Sydney Grammar School Weigall Sports Complex (SSD-10421)

Response to Submissions

Part 1 – Response to Public Authority Submissions

Top: Sports Facilities Building - East Elevation  
Bottom: View along Vialoux Avenue

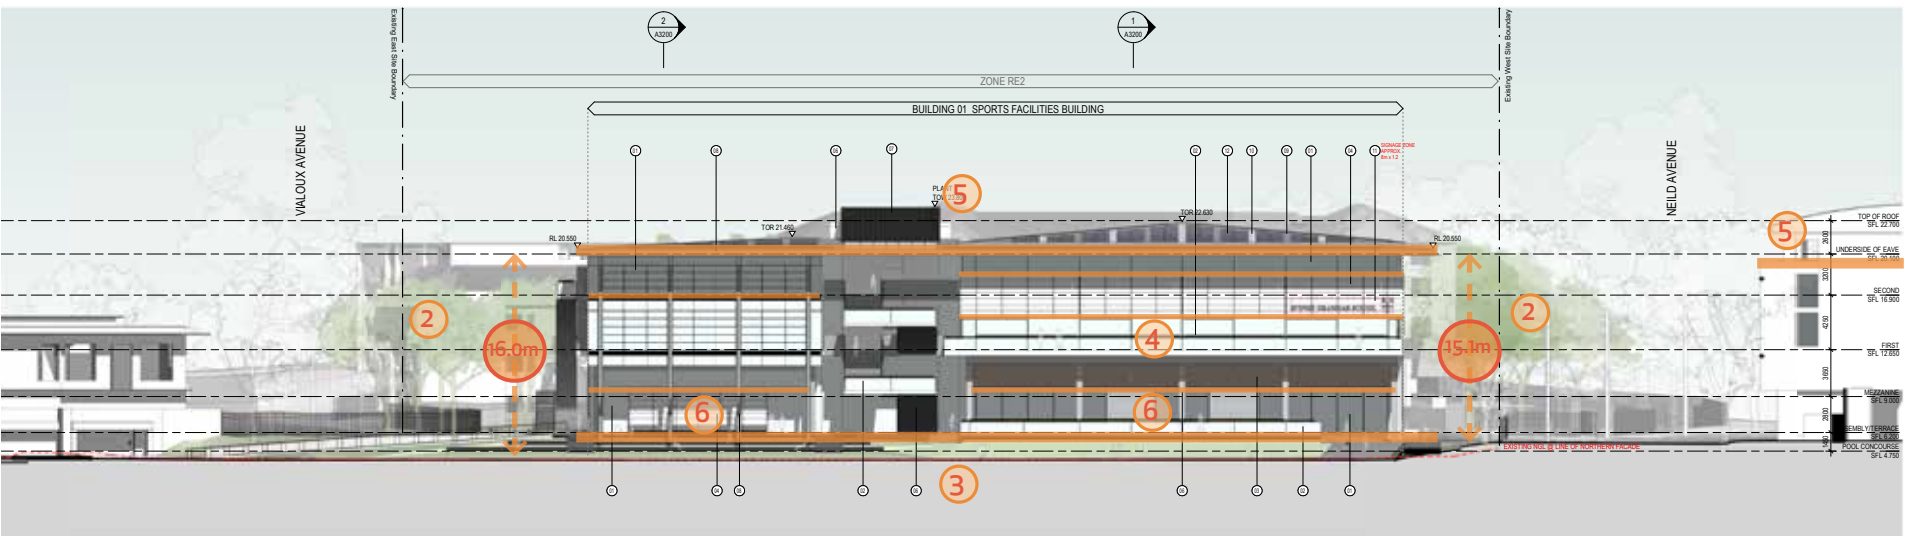
Issues Raised by Organisations	Type of submission	Proponent's Response
 <p><i>Figure 1 – Proposed Building 1 eastern elevation with the smaller built form of 8 Vialoux Avenue immediately adjacent (source AJ+C Architectural Drawings)</i></p>  <p><i>Figure 2 – Montage of the built form and its over bearing relationship with built form adjacent and blocking outlook from the neighbouring owners now not visible (source AJ+C Architectural Drawings)</i></p>

Issues Raised by Organisations	Type of submission	Proponent's Response
		<p>pursuant to SEPP (Education and Child Care) 2017 could have a height of up to 18.5m on the Zone R3 land which is up to 8m above the height standard (see RtS Design Report, Appendix C).</p> <ul style="list-style-type: none">• Generous setbacks and landscaping is proposed where the site adjoins land in Zone R3• Views, overshadowing and privacy impacts have been considered in detail in the EIS and RtS.
